A57 Link Roads

**9.13 Draft Statement of Common Ground
with Peak District National Park Authority**

9.13 DRAFT STATEMENT OF COMMON GROUND WITH PEAK DISTRICT NATIONAL PARK AUTHORITY

Table 3.2: Table of Issues/Matters - Final Version dated 6th January 2022.

© OpenStreetMap (and) contributors. CC-BY-SA
 Contains OS data © Crown Copyright and database right

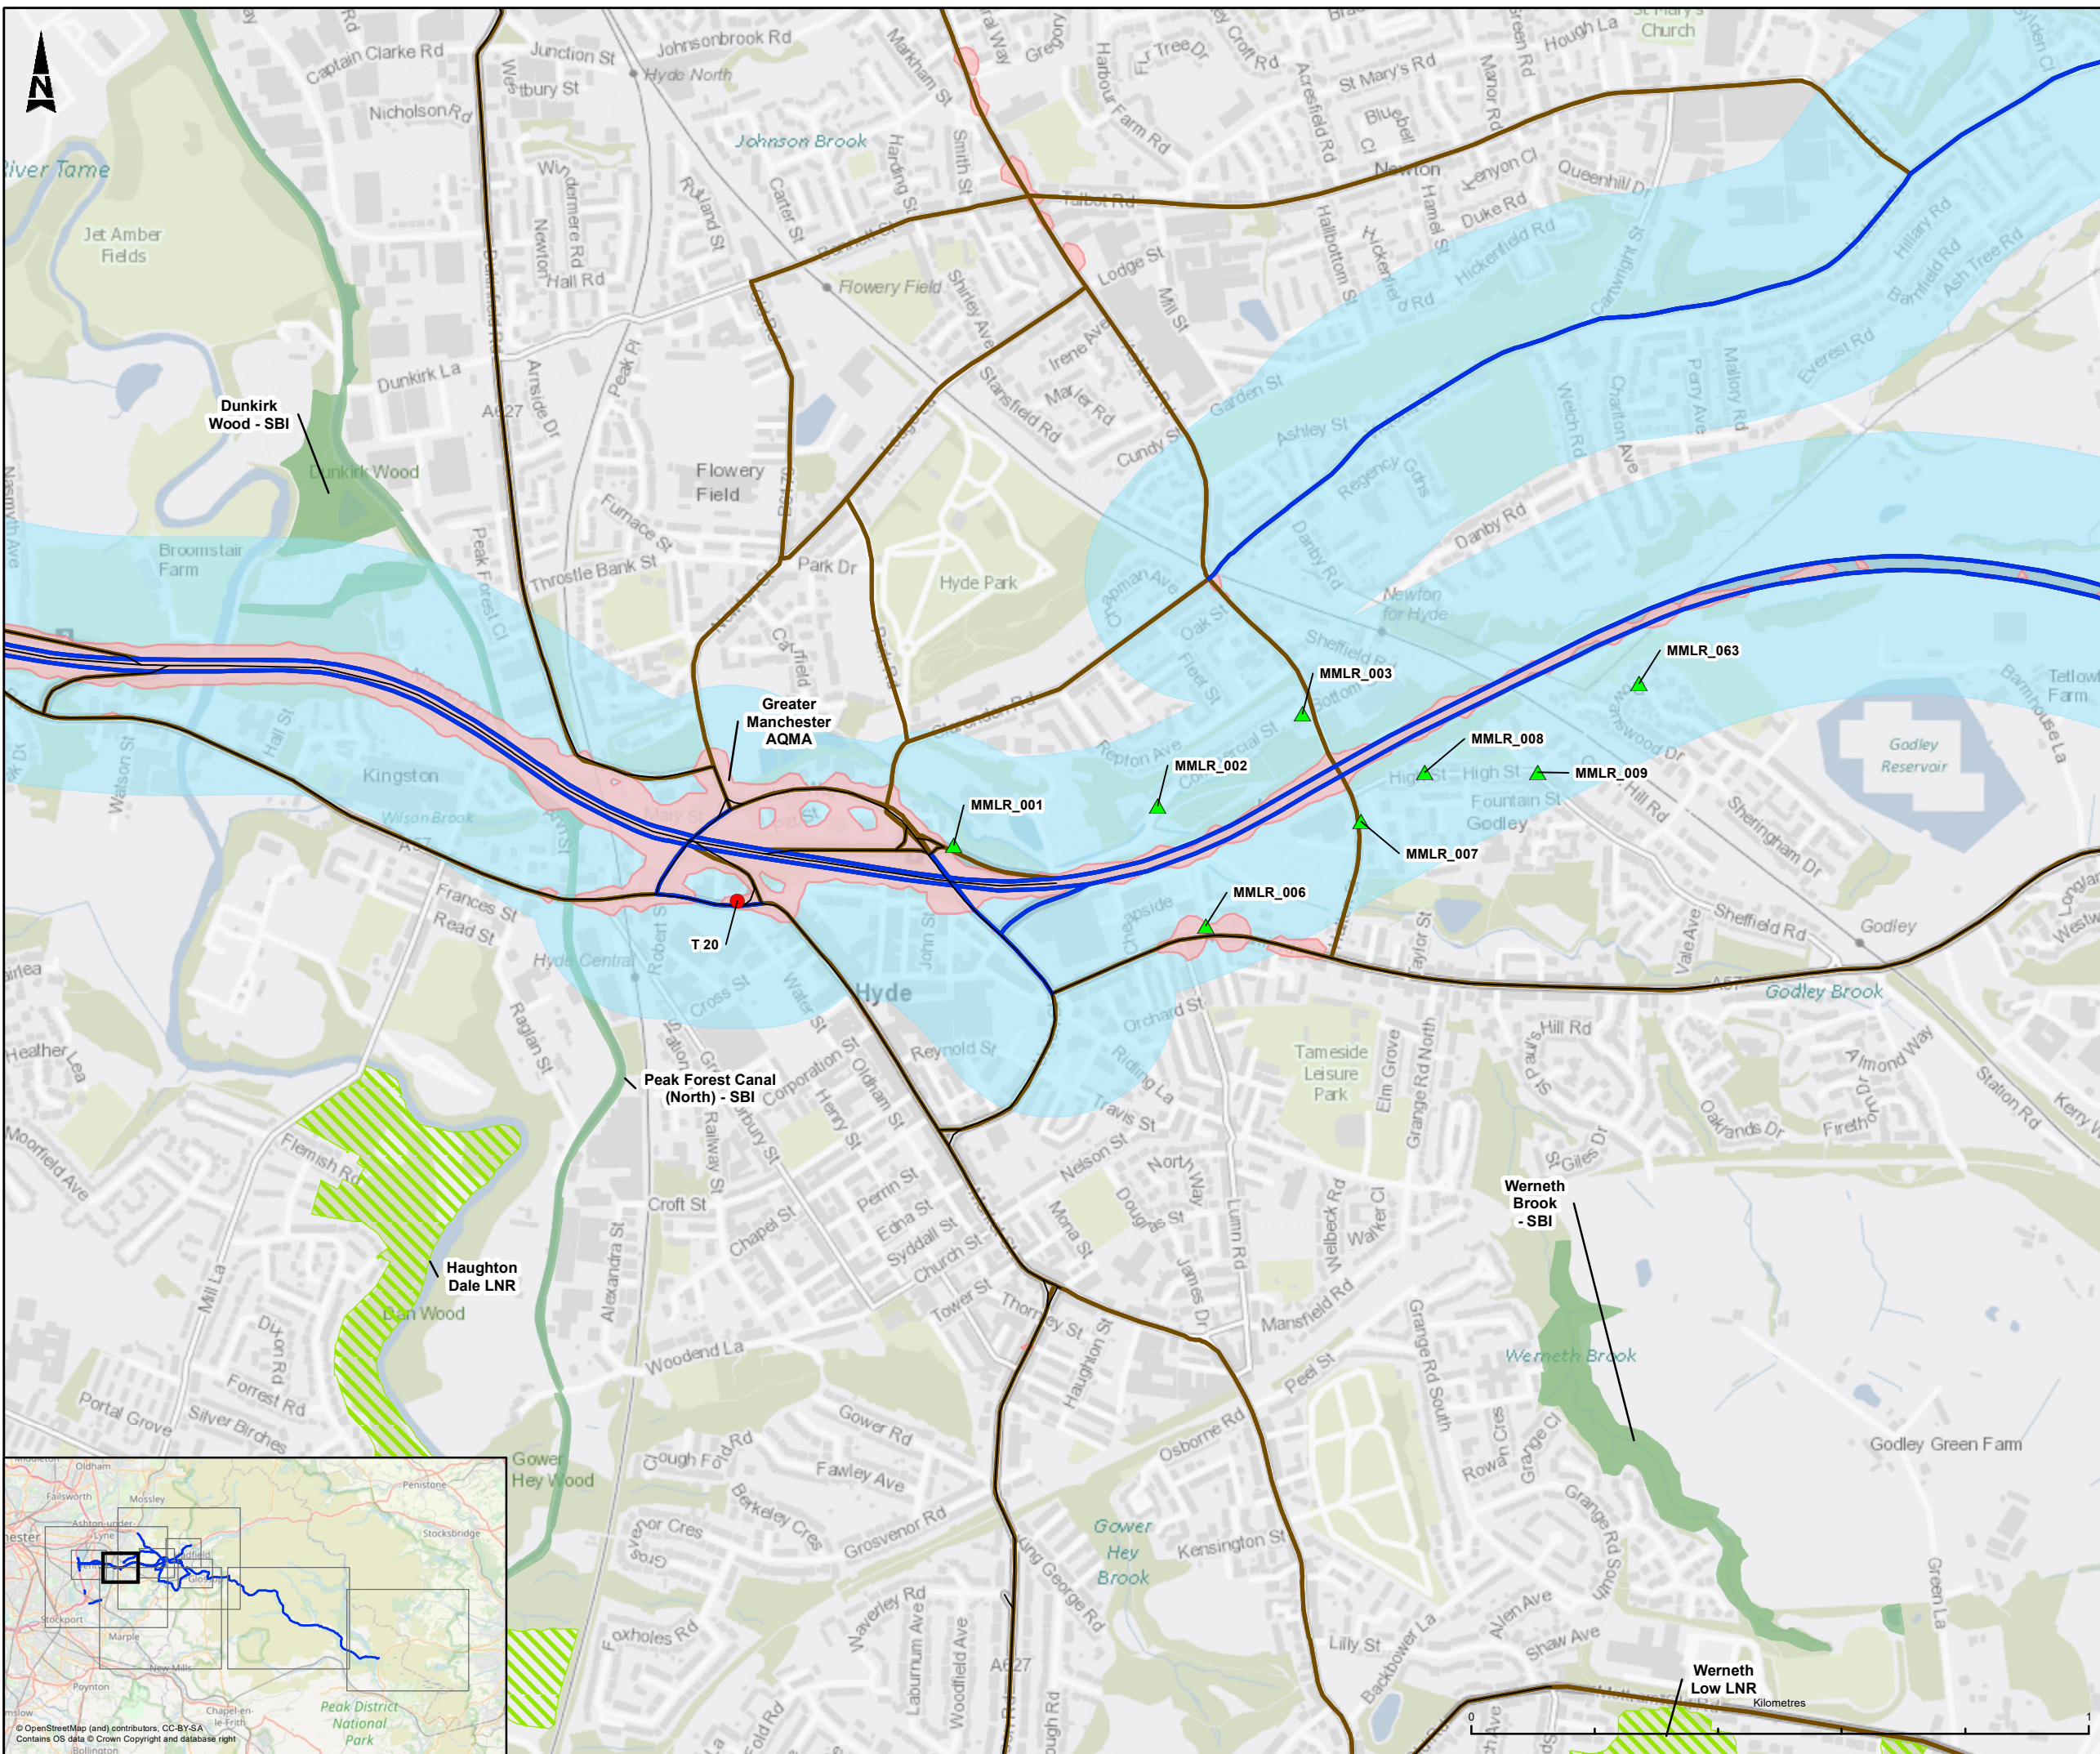
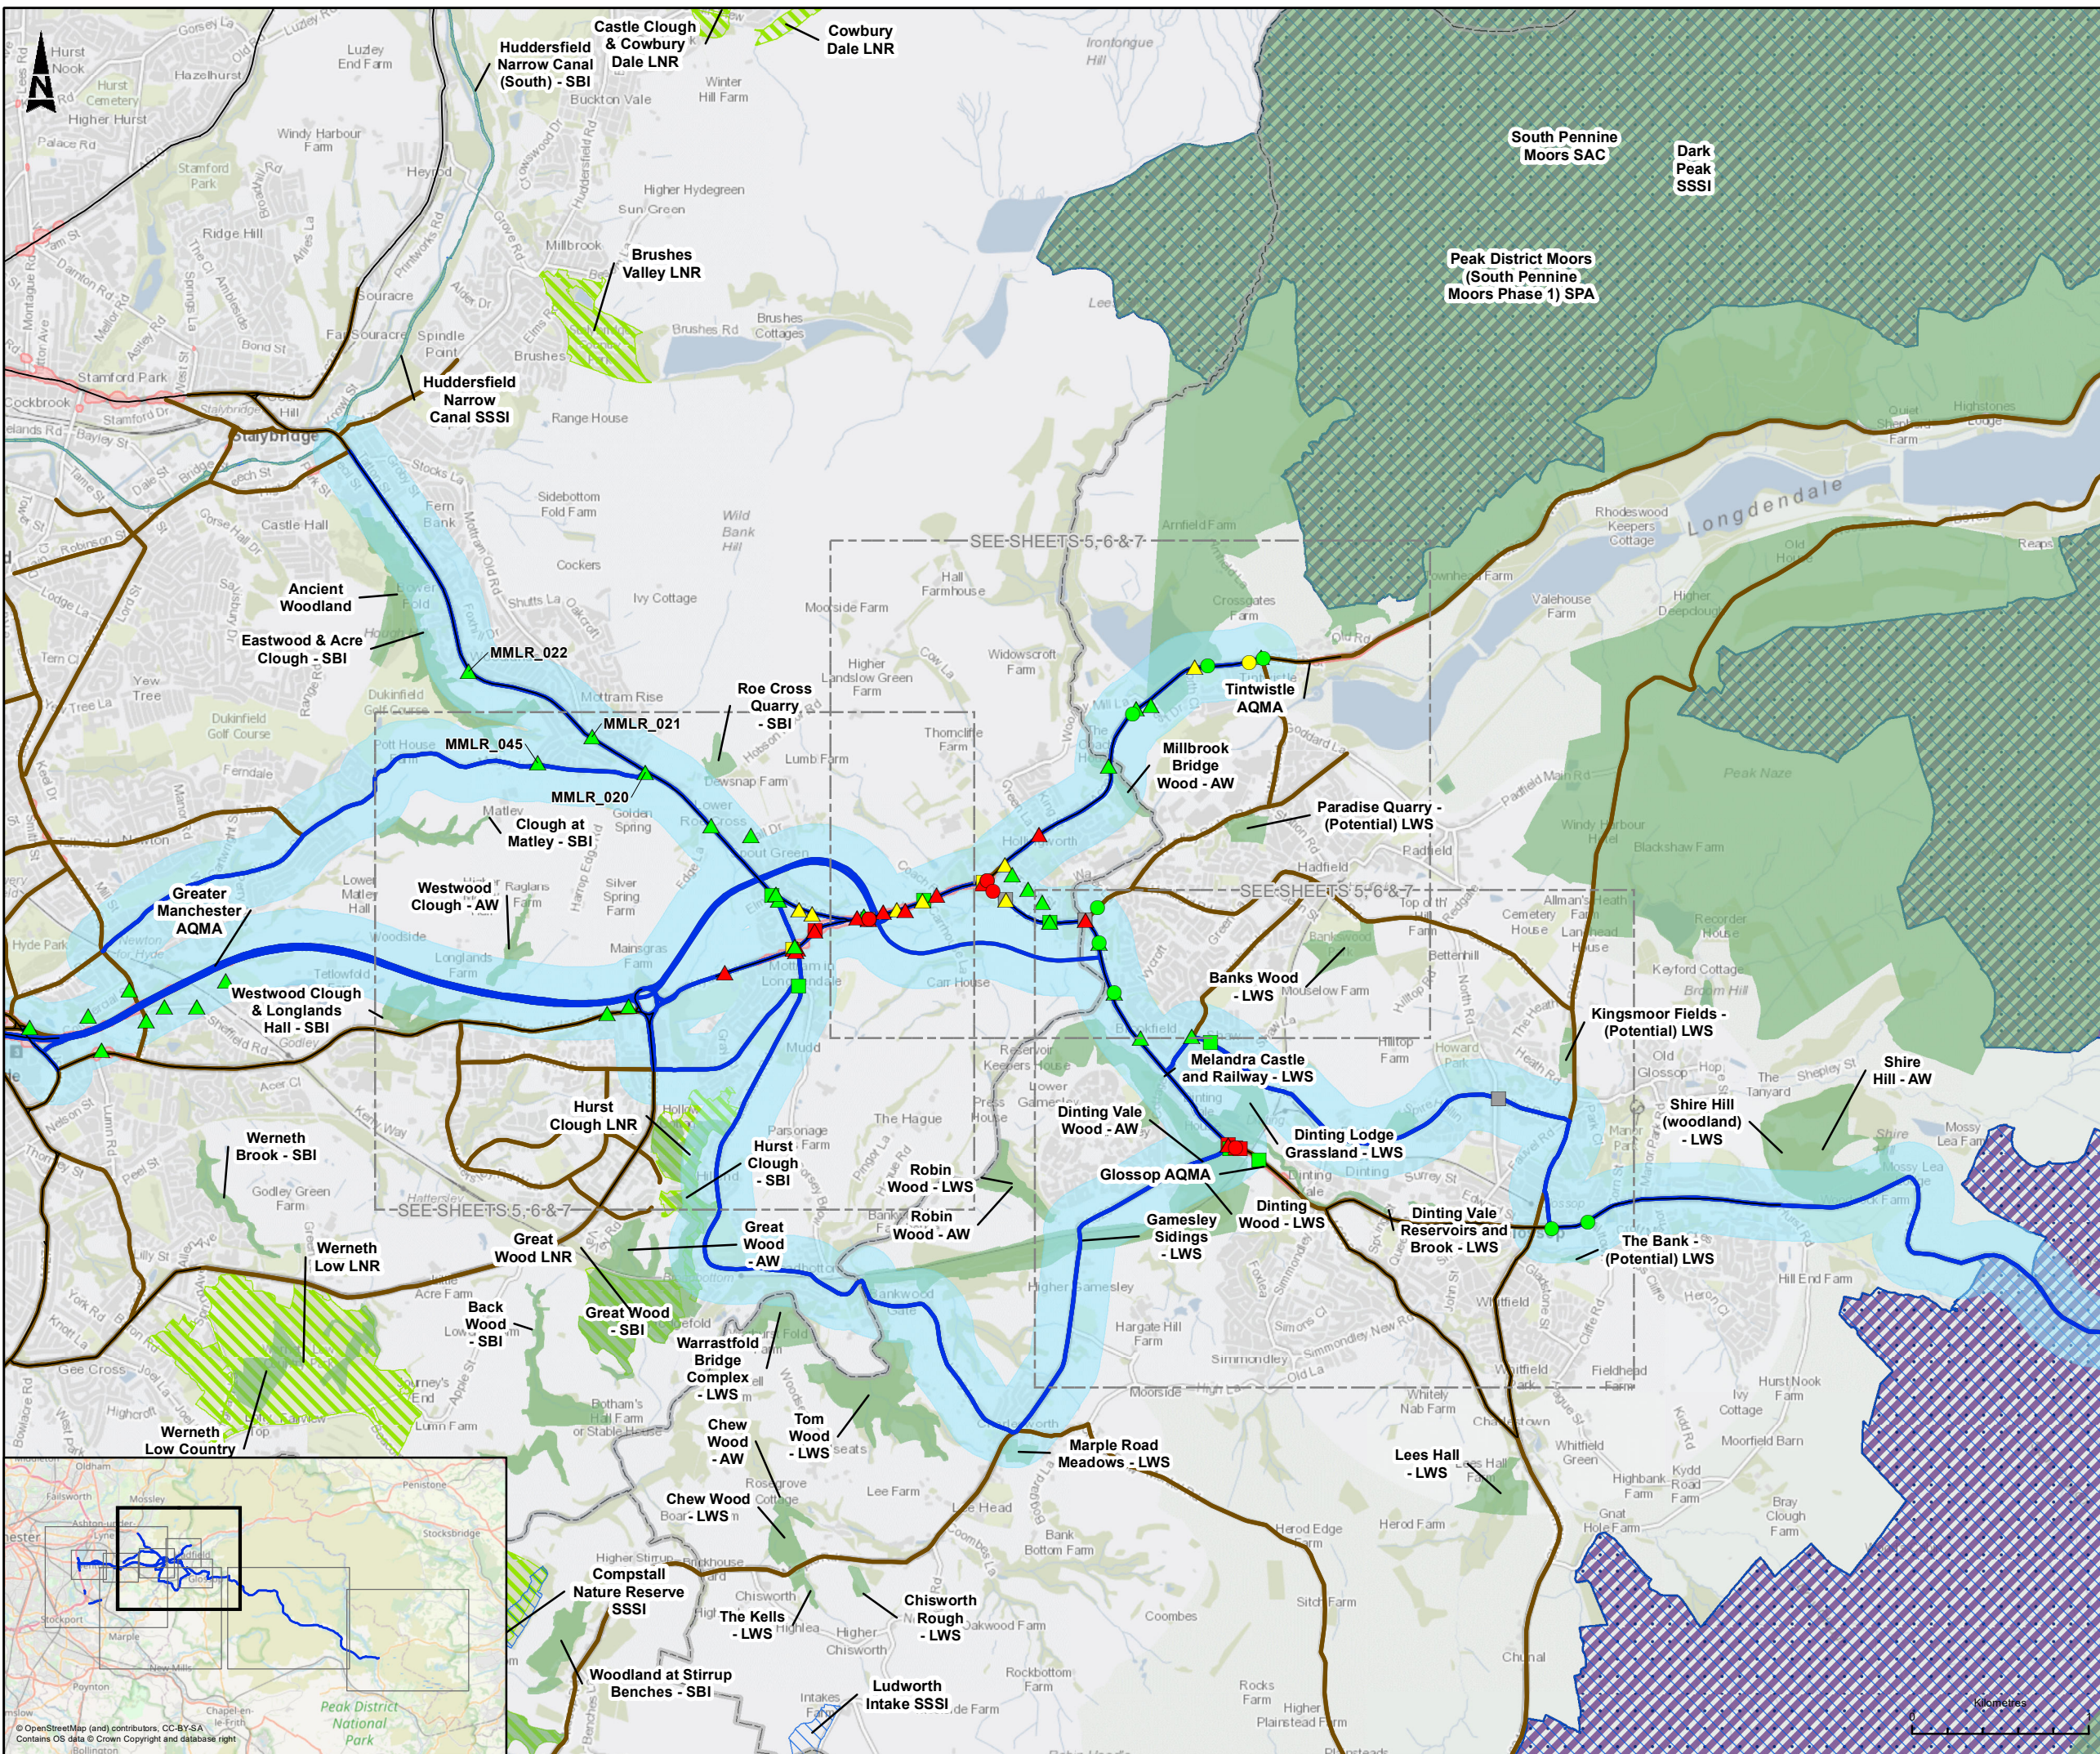
2.3.1	ES Chapter 5: Air quality (APP-061)	Effects on air quality and designated sites	<p>From the PDNPA Relevant Representation (RR-0677-3):</p> <p>We have concerns regarding the effects of the scheme on the following:</p> <p>1) Air Quality a) Tintwistle AQMA –is acknowledged within the ES, however, there is no assessment of the effects of the predicted increased traffic flows on it.</p> <p>b) Designated sites (A628) – are already subject to high traffic flow and associated Nitrate deposition. Whilst predicted increased flows for 2025 do not meet the 1,000-vehicle threshold, we believe that an assessment of impact should have been undertaken.</p>	<p>National Highways response to PDNPA Relevant Representation (RR-0677-3):</p> <p>The study area for the assessment of impacts on air quality of the operational phase of the Scheme has been determined in accordance with the National Highways Design Manual for Roads and Bridges (DMRB) LA 105 Air Quality standard, which ensures that the scheme can demonstrate compliance with the NPSNN. The DMRB LA 105 standard defines traffic change criteria for determining whether air quality impacts can be scoped out or require assessment (DMRB LA 105 paragraph 2.1) based on the changes in annual average daily traffic (AADT) flow, heavy duty vehicle (HDV) flows and speed. The key traffic change criteria are the flow change criteria - a change of over 1000 AADT and a change of over 200 HDV with the Scheme compared to without the Scheme in the Scheme opening year of 2025. The traffic change criteria has been applied to traffic output from the scheme specific traffic model to determine the Affected Road Network (ARN). The scheme specific traffic model includes strategic roads, including the A628 through the Tintwistle AQMA and ecologically designated sites. The extent of the ARN is presented in Figure 5.1 of the Environmental Statement (APP -076). The traffic change criteria are not exceeded for the A628 through the Tintwistle AQMA or for sections where there are ecologically designated sites adjacent and as a result is not included in the air quality assessment. Where traffic change criteria are not exceeded on roads they are not considered further in the air quality assessment. It is considered that impacts from a scheme on traffic flows below, this criteria is not considered to be significant.</p>	Under discussion
